BE/33/14/HH

17, Frander Rd
Bognor Regis

27th March 2019

*Proposed Conservatory installation, frames white UPVC@
17 Frandor Road, Bognor Regis, PO21 5TP
Proposed Floor plan*

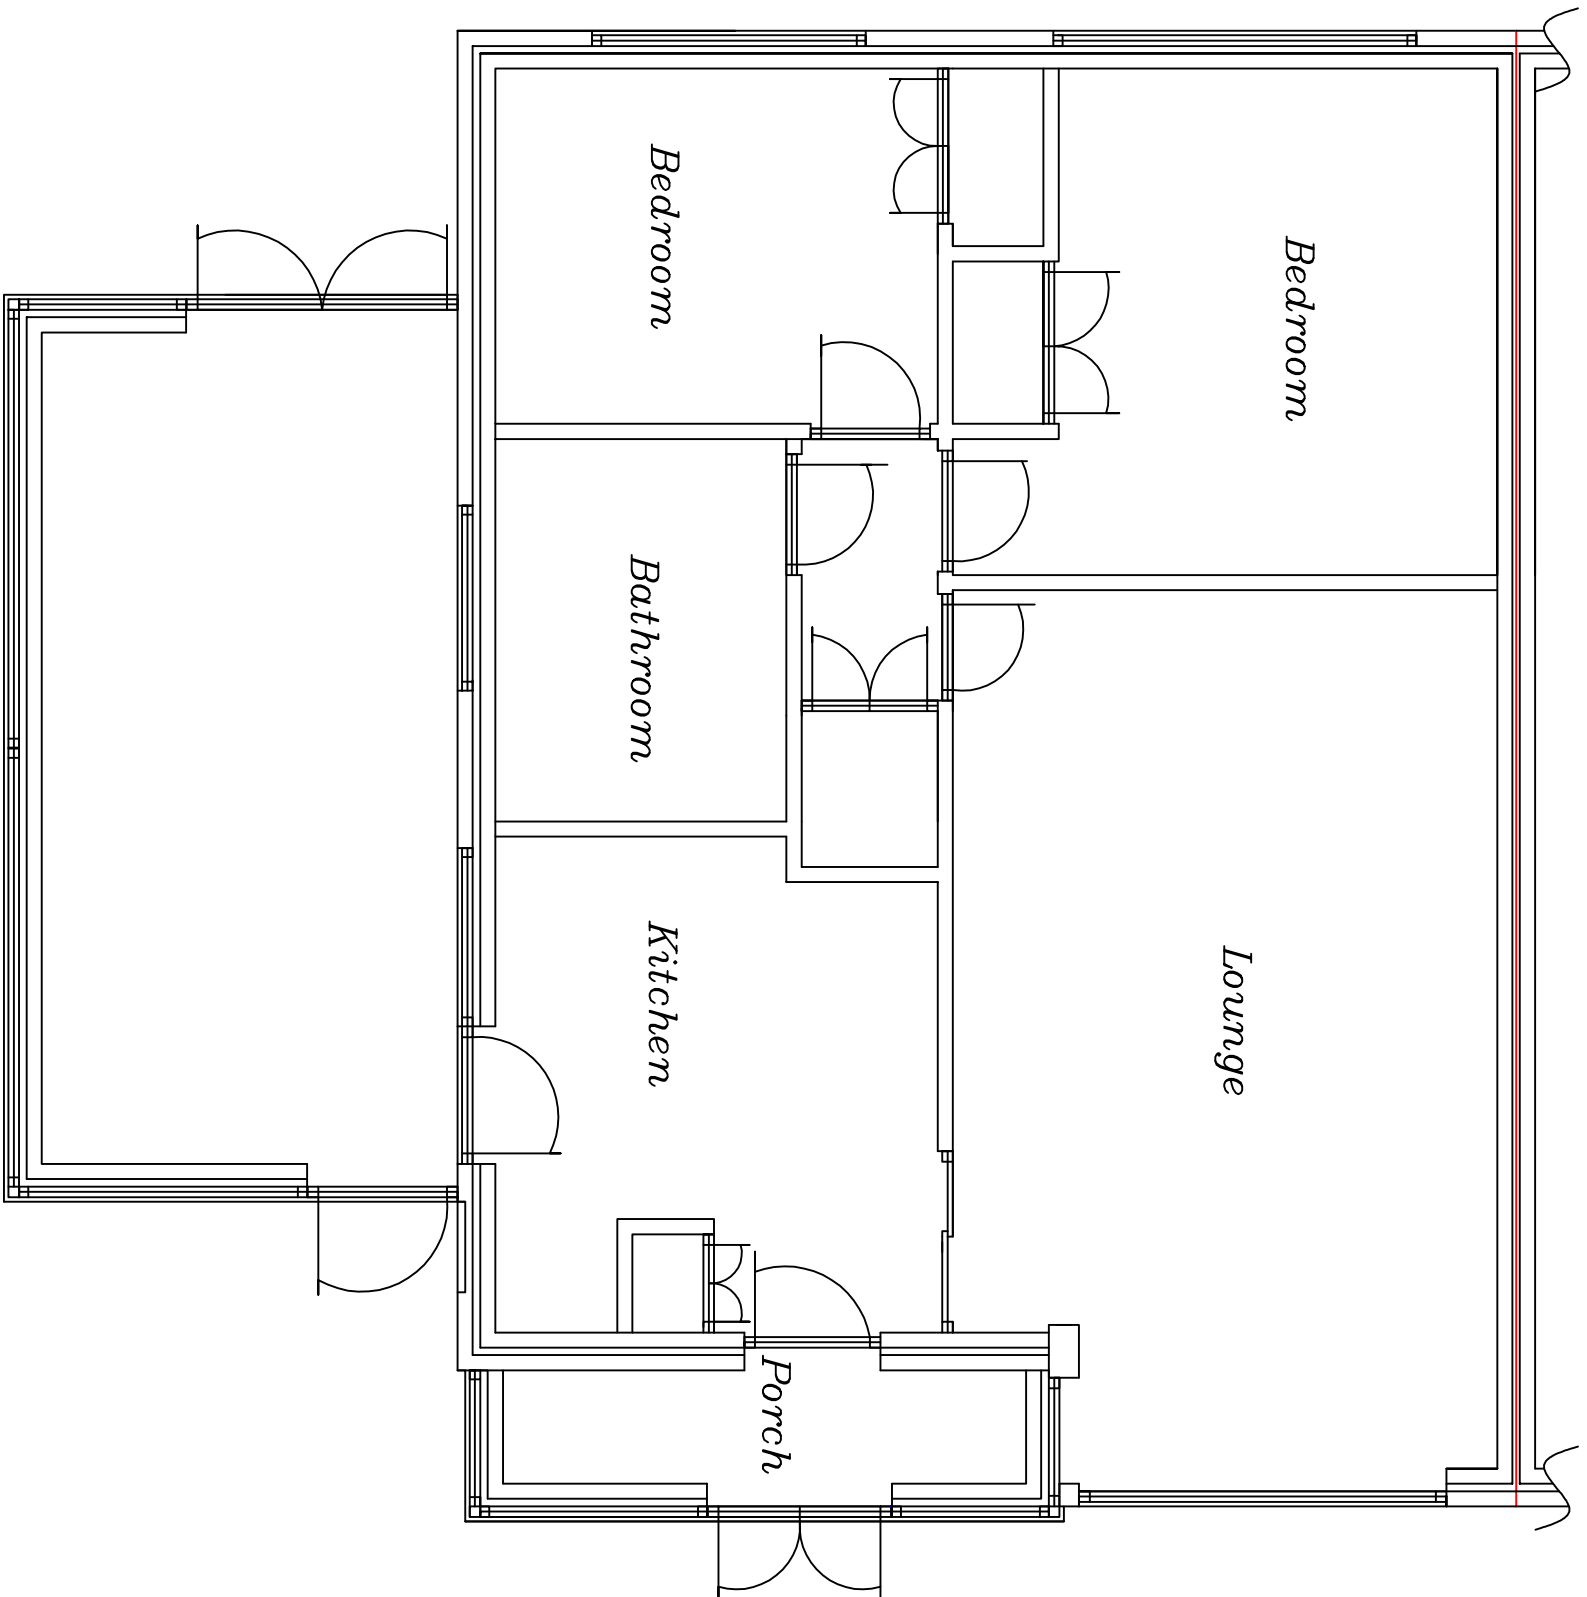
Dear Head of Planning,
I wish to point out that the plans for a conservatory on the side of 17, Frander Rd are incorrect. The garage to the side of the bungalow was sold by the previous builder owner to a gardener along with the front drive. The plans & red line suggest the garage is owned by the bungalow's current owners and it isn't. The gardener negotiated with the former owner and now owns it.

The conservatory has no dimensions written on the plans either and we as neighbours are concerned this could be open to change as no such dimensions are in writing.
